DEVELOPMENT REVIEW BOARD SUPPLEMENTAL SUBMITTAL

PROJECT NO. 1009178

**Re: Vacation of Walkway between Lots 6 and 7, Block 9, Volcano Cliffs, Unit 18
Project# 1009178**

DEVELOPMENT REVIEW BOARD – SPEED MEMO

SKETCH PLAT
TIBURON HEIGHTS
 WITHIN THE
 CITY OF ALBUQUERQUE
 BERNALILLO COUNTY, NEW MEXICO
 OCTOBER, 2012

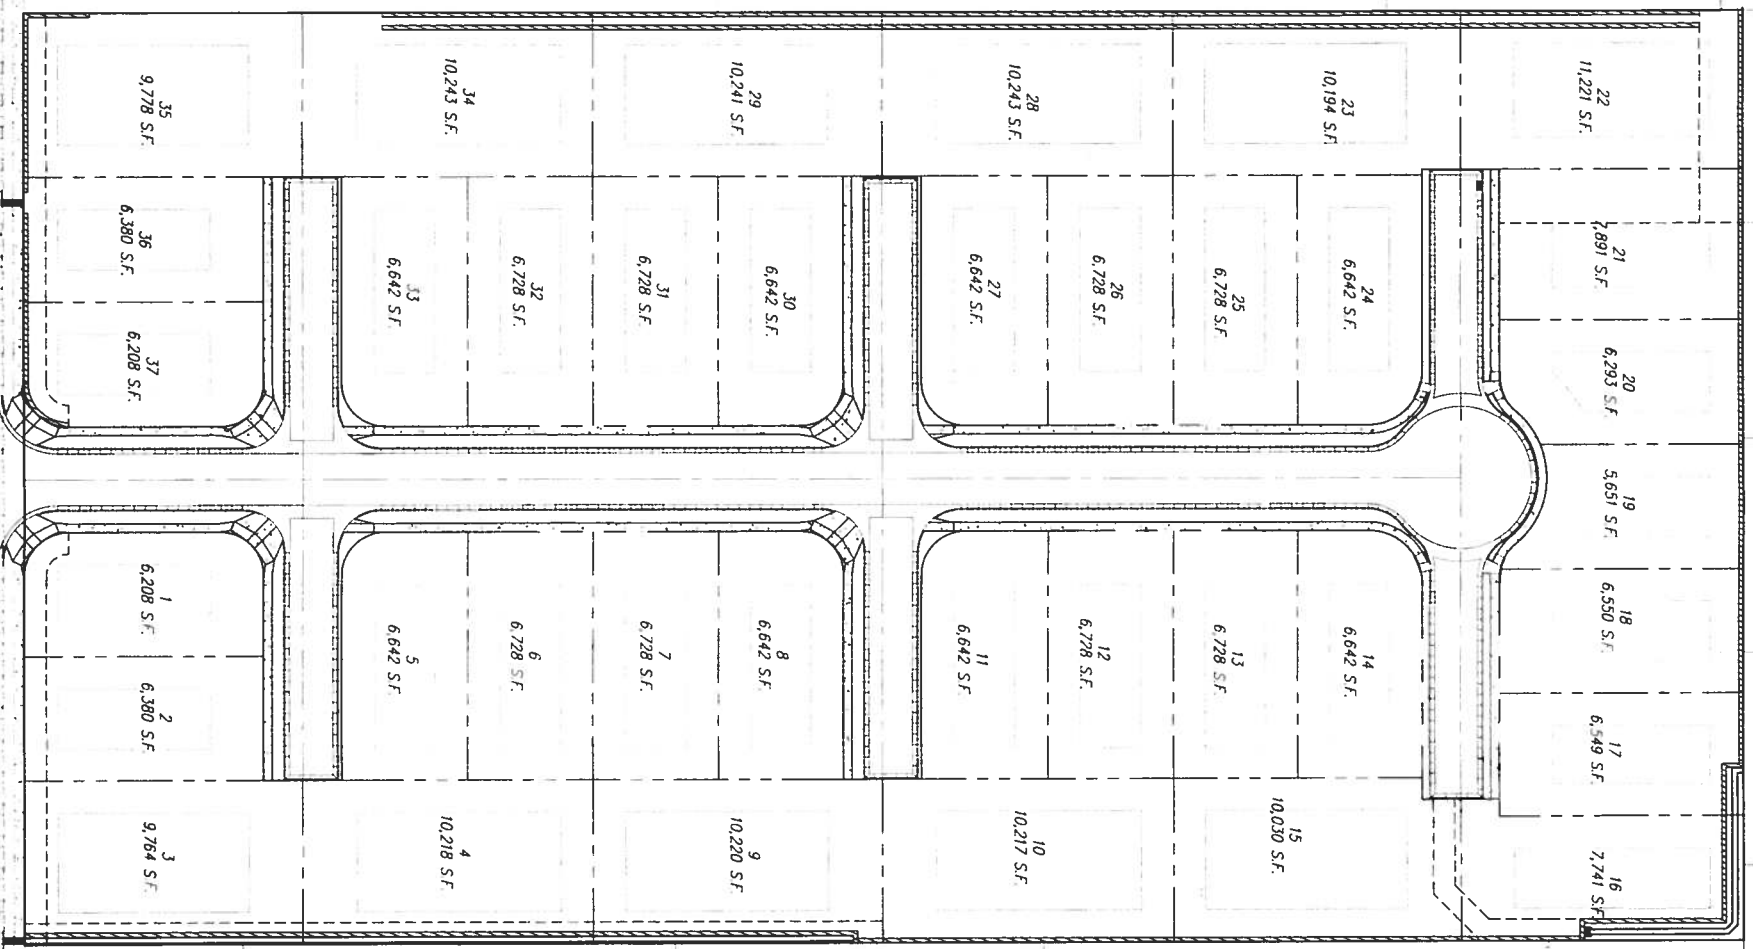
Is Lot 31 intended to be a park?

It is difficult to determine if more than one pedestrian walkway easement is provided for access to Lot 31.
Please clarify.

NOTES: From Larry Medrano, I understand you had a question about the access for Lot 31, which abuts the request for vacation of a 10 walkway easement. Here is a copy of the proposed Sketch for Lot 31, indicating all access will be from Petirrojo Road.
